Our ref: DOC25/699192
Your ref: SSD-10269-Mod-1

Narrabri Underground Mine Stage 3 Extension – Modification 1 – Response to Submissions

Narrabri Underground Mine Stage 3 Extension – Modification 1 – Response to Submissions

Figure 3: Project Phasing for Offsets

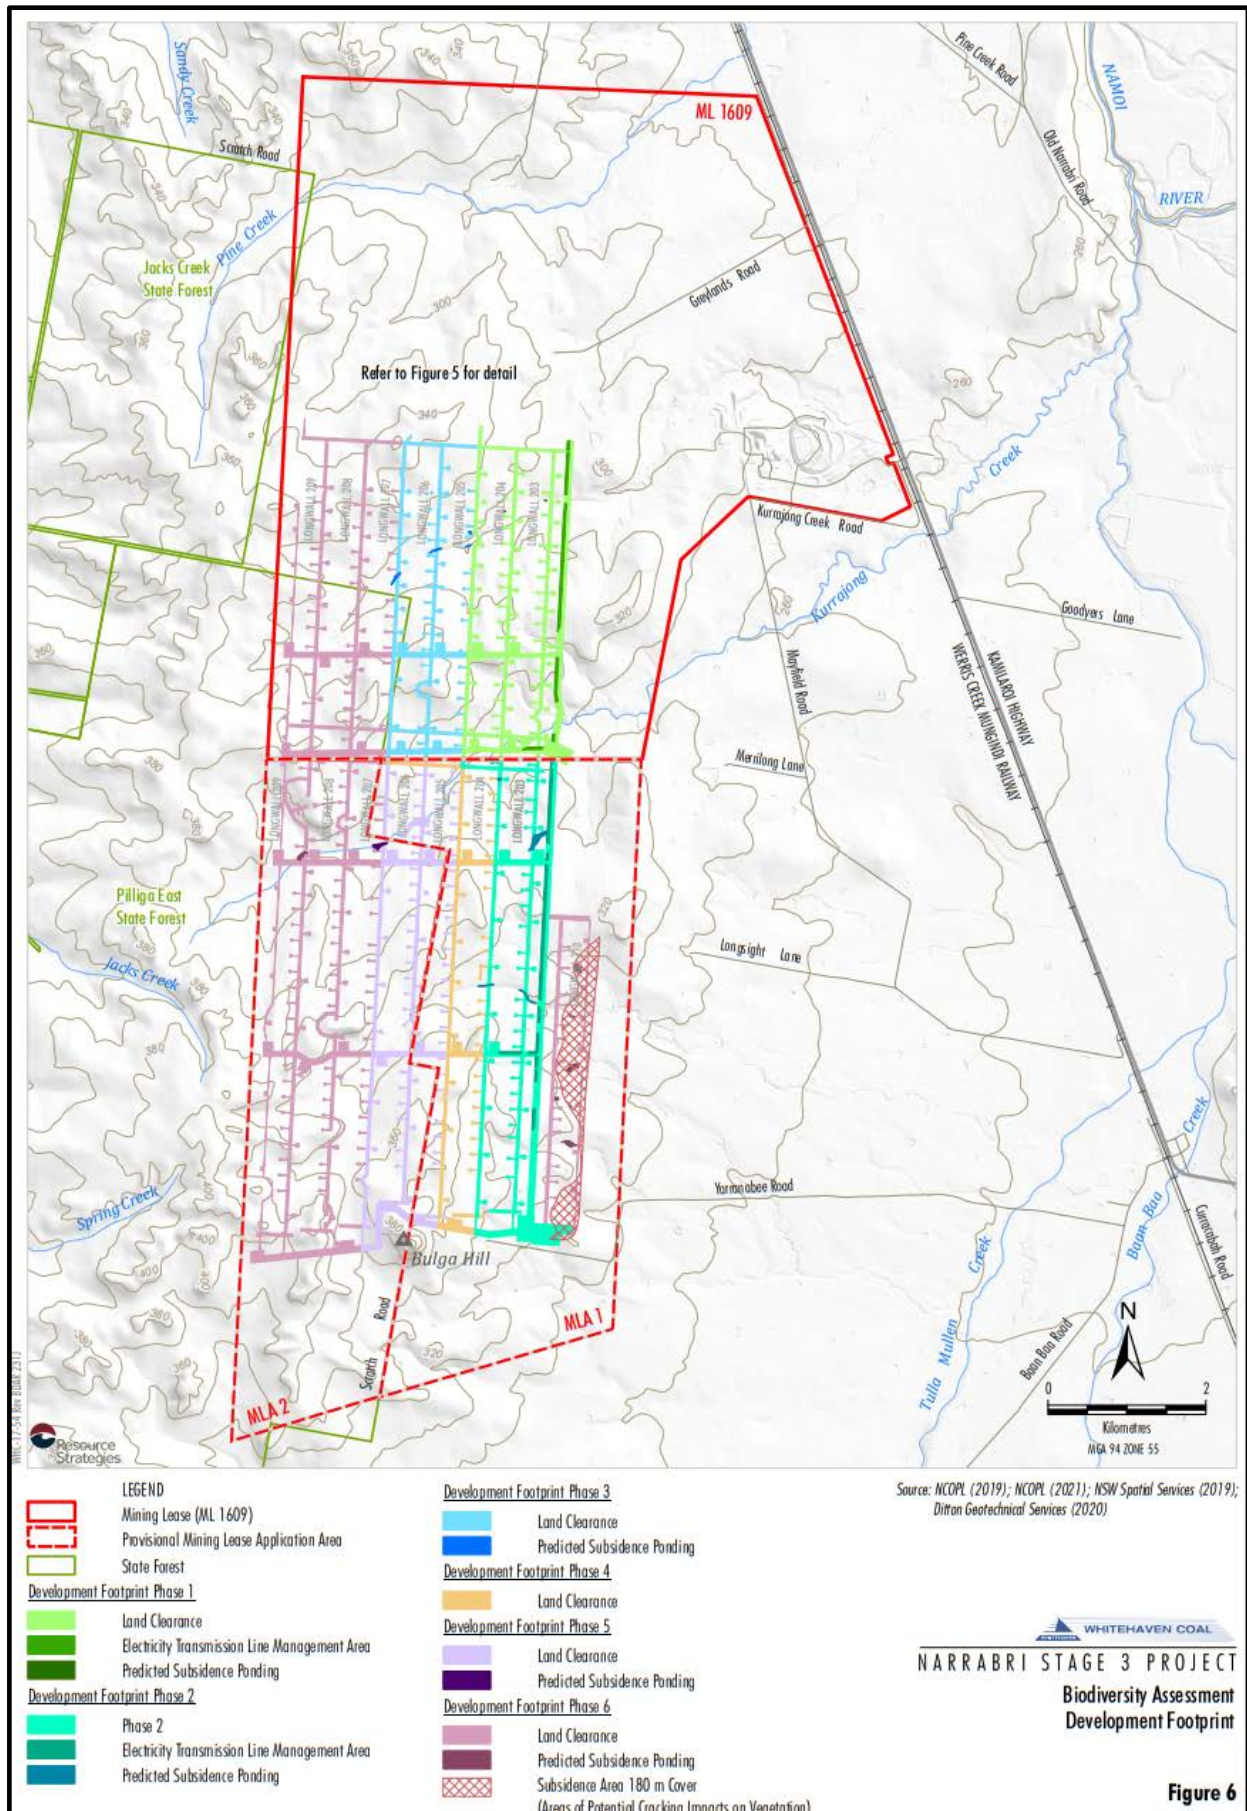
- 2.1 CPHR is willing to support the subdivision of Phase 6 into Phase 6a-6c, contingent on recent changes to the credit obligation being validated. The acceptance of the revised staging does not imply endorsement of future credit reductions under condition B40 for these areas.

The RTS introduces new contextual information explaining the rationale behind the subdivision of Phase 6 into Phases 6a–6c. This includes providing an alternative mining layout and citing ongoing mining and vegetation clearance under the Stage 2 consent. This context was absent from both the original MOD 1 document and the previous requests under condition B40 to reduce the project's credit obligation.

Based on this new information, CPHR is prepared to accept the proposed subdivision of Phase 6, subject to recommendations 1.1 and 1.2 of this response being addressed. However, CPHR emphasise that acceptance of the revised staging does not imply endorsement of future credit reductions under condition B40 for these areas.

2.1 CPHR supports the subdivision of Phase 6 into Phase 6a-6c, contingent on recent changes to the credit obligation being validated.
